0293 Pl. Applic.
10th May 2012

Re: R/99/12/ 1 Botany Close, West Sussex BN16 2BH – Householder Planning Application

Further to your correspondence we formally submit the following amended planning drawings.

10.05.12	1: 200 @ A3	0293(01)10	D	
DyerGrimes		The Old Boathouse, 1A Embankment, Putney, London, SW15 1LB T: 020 8780 5930 E: enquiries@dyergrimesarchitects.com

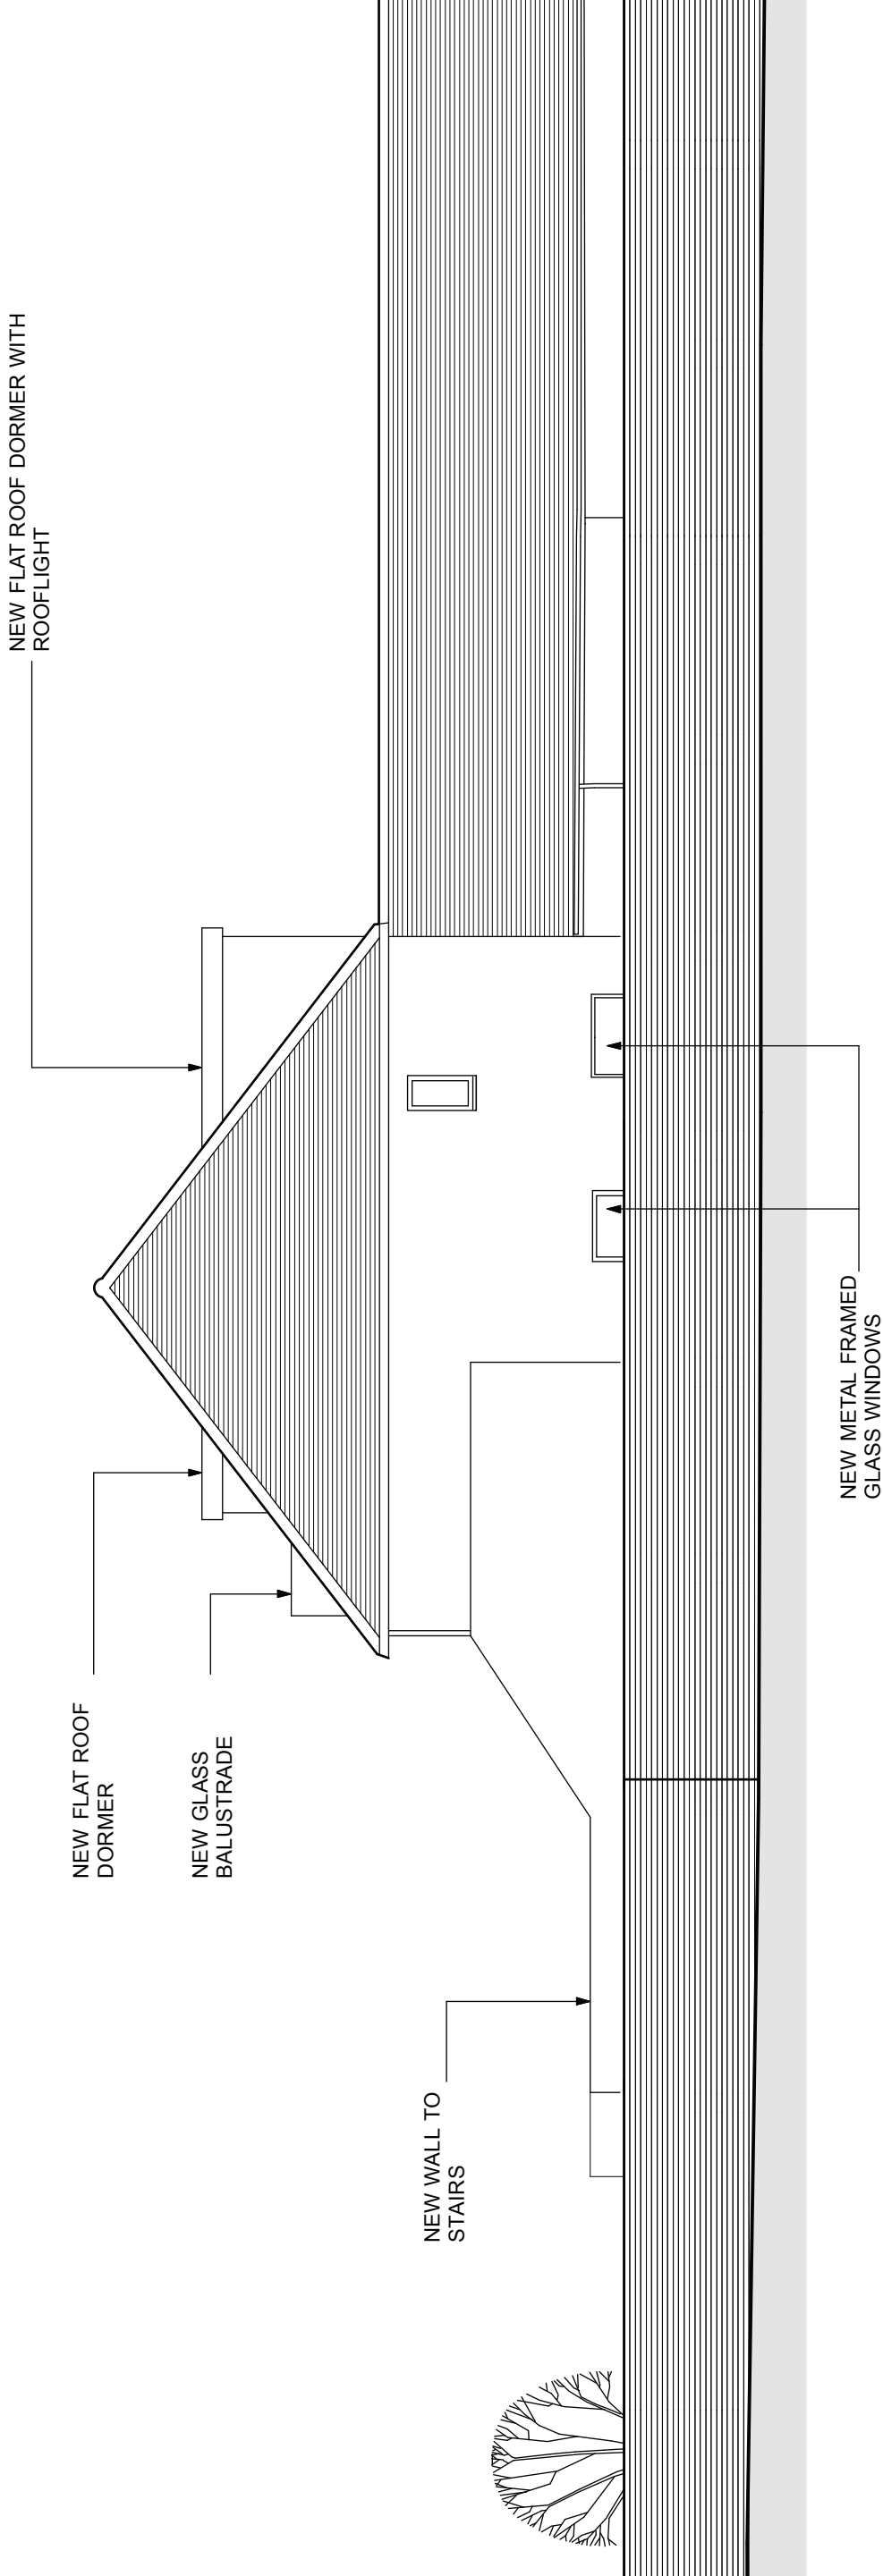
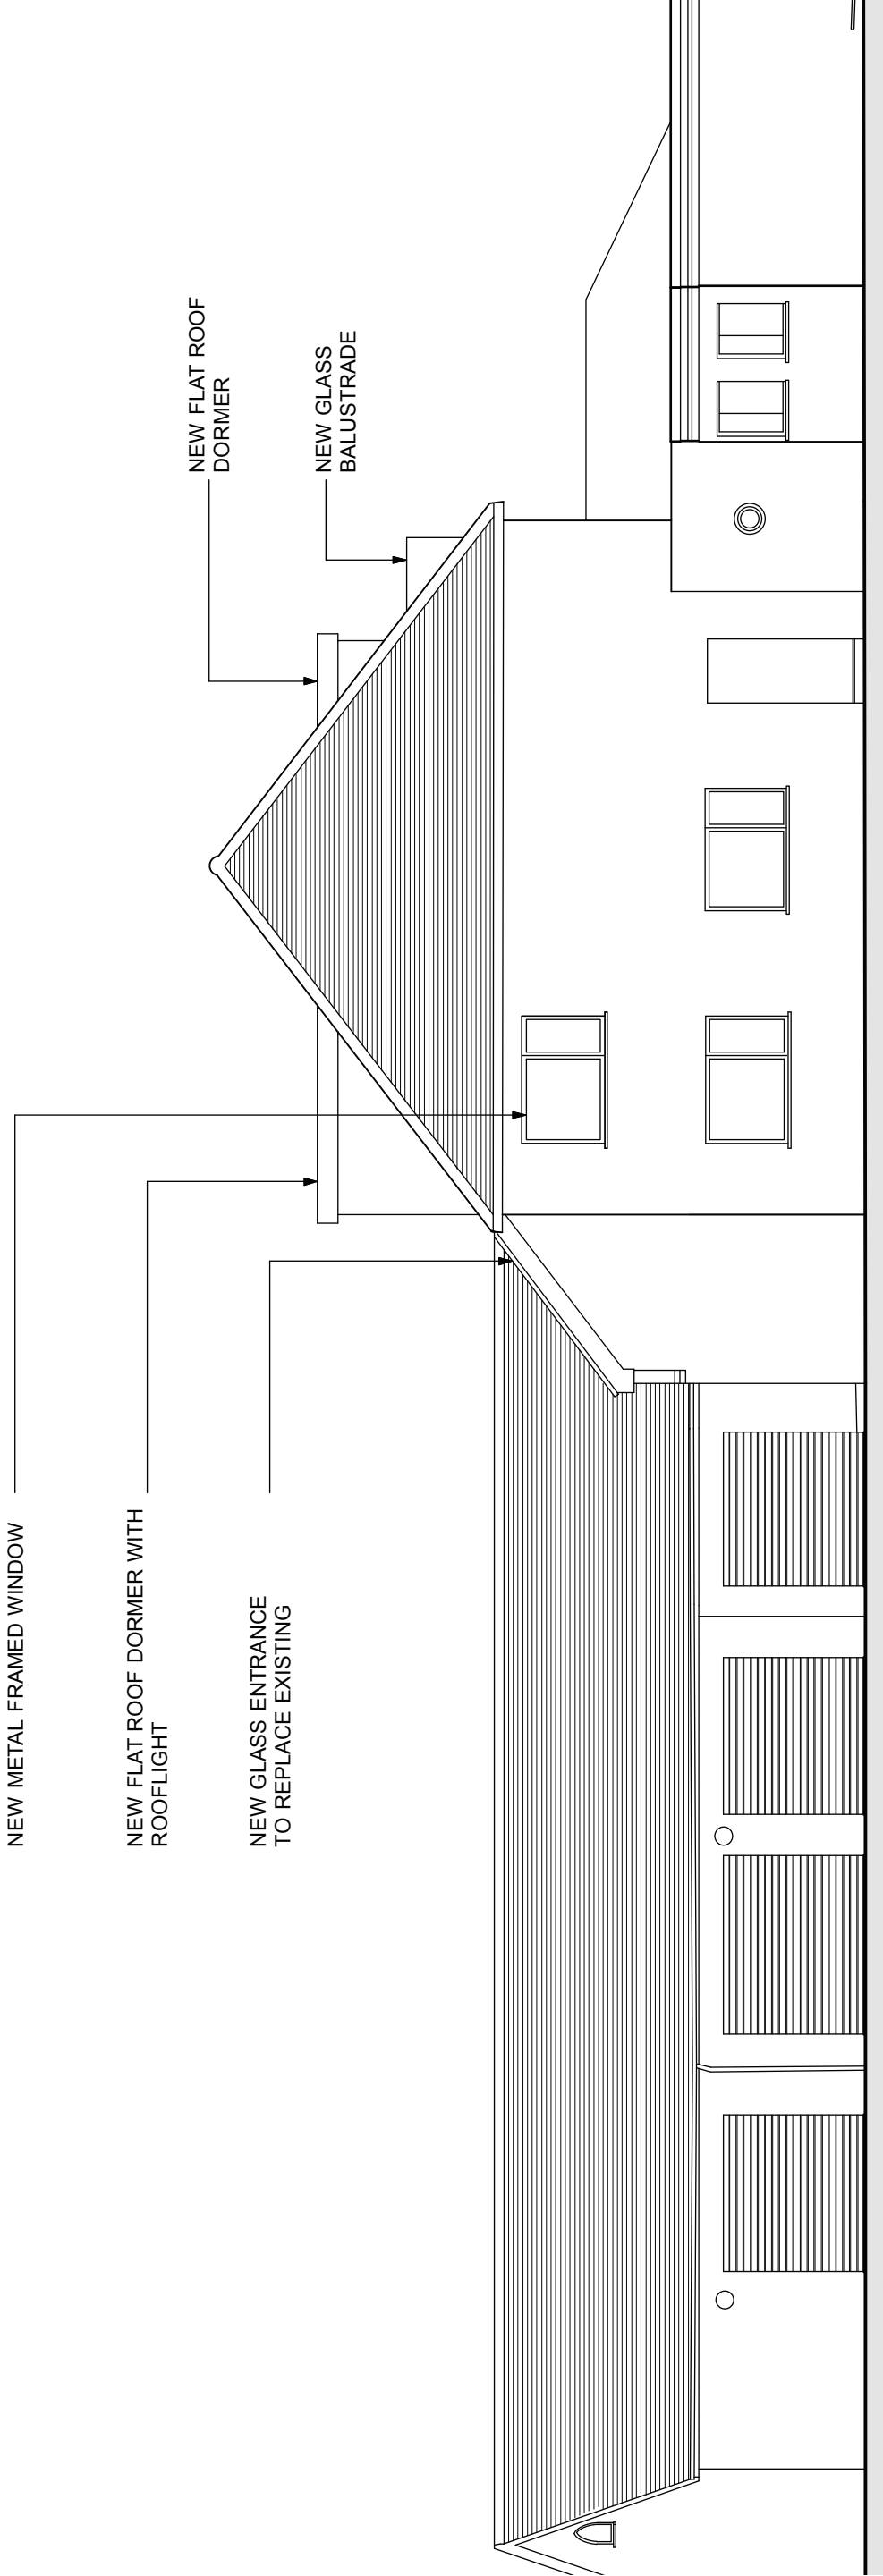
0293(00)10 Existing East Elevation, 0293(00)11 Existing West Elevation, 0293(01)10 Proposed East Elevation and 0293(01)11 Proposed West Elevation have been amended as requested to identify the correct orientation.

0293(01)06

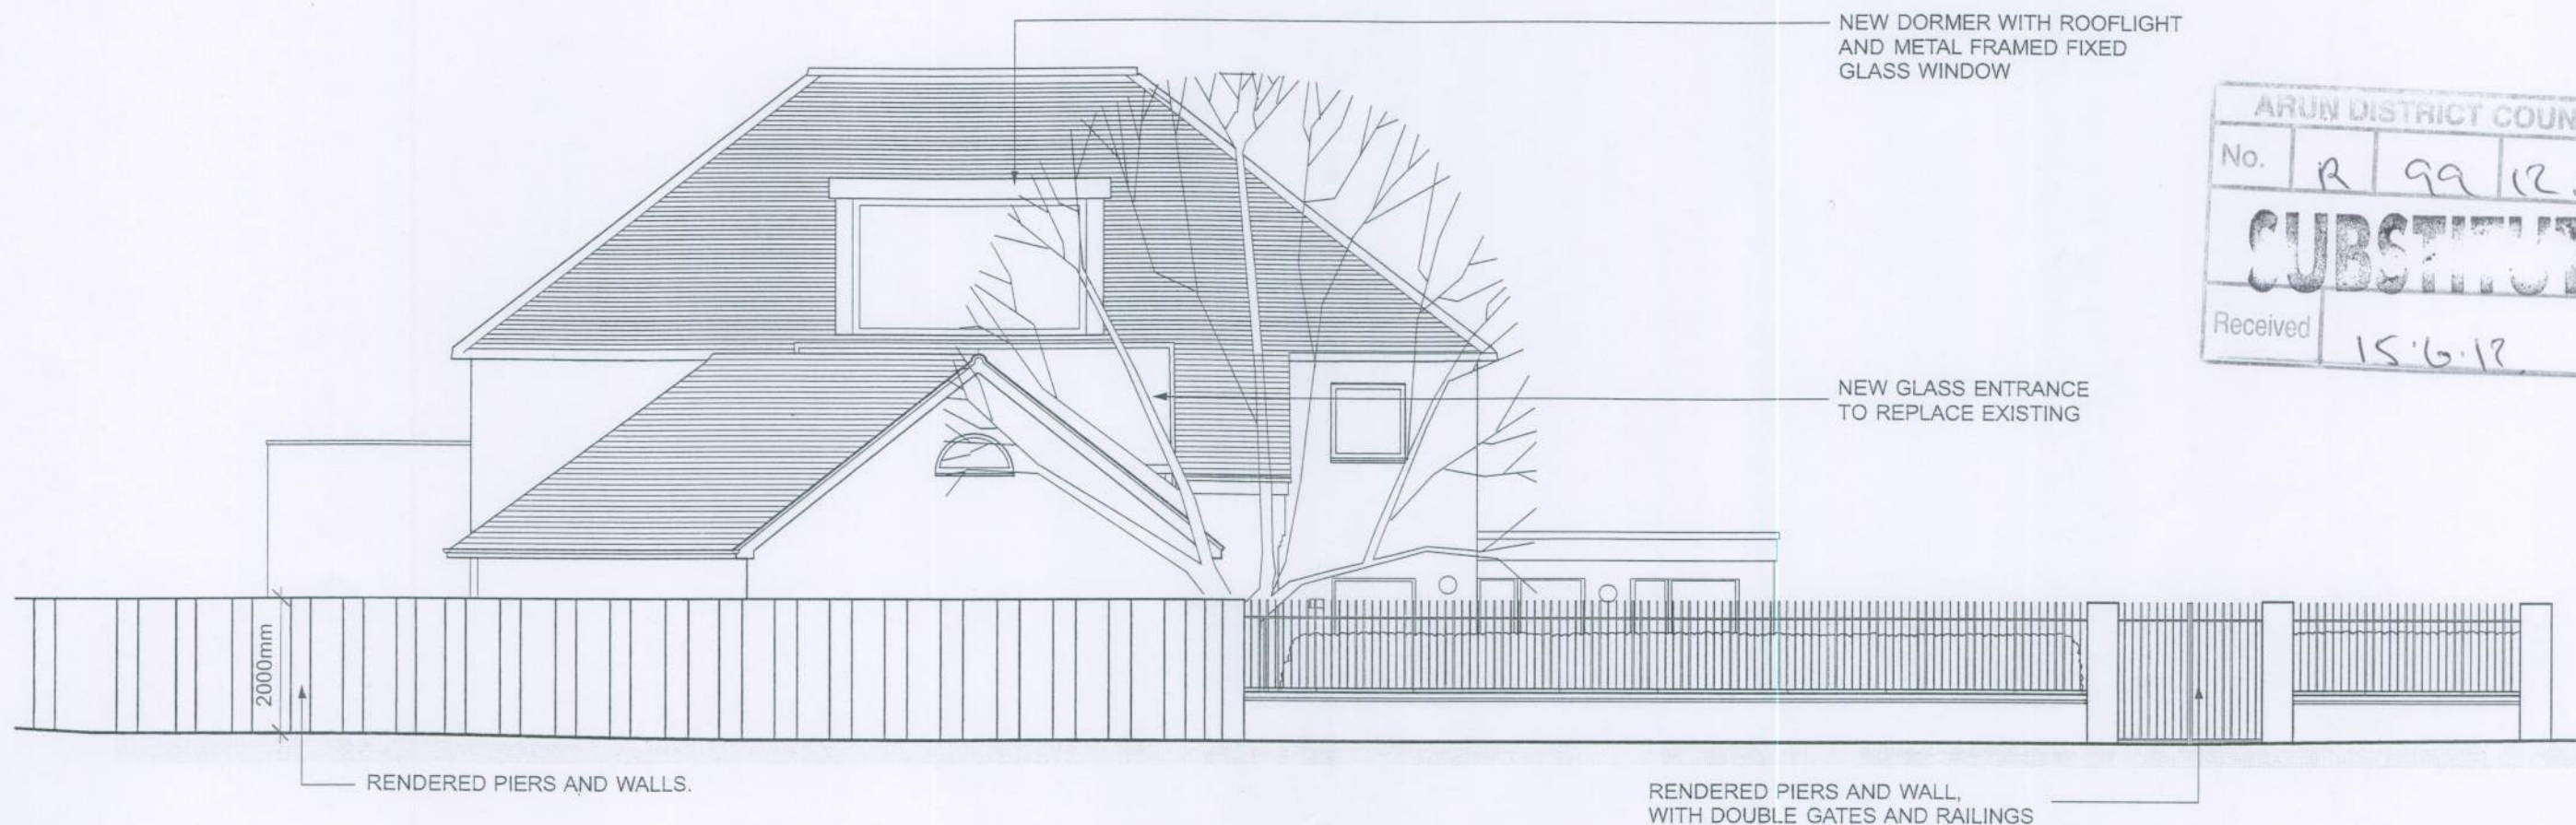
0293(00)06 Existing Street Elevation and 0293(01)06 Proposed Street Elevation illustrates that the high level crescent window is being retained.
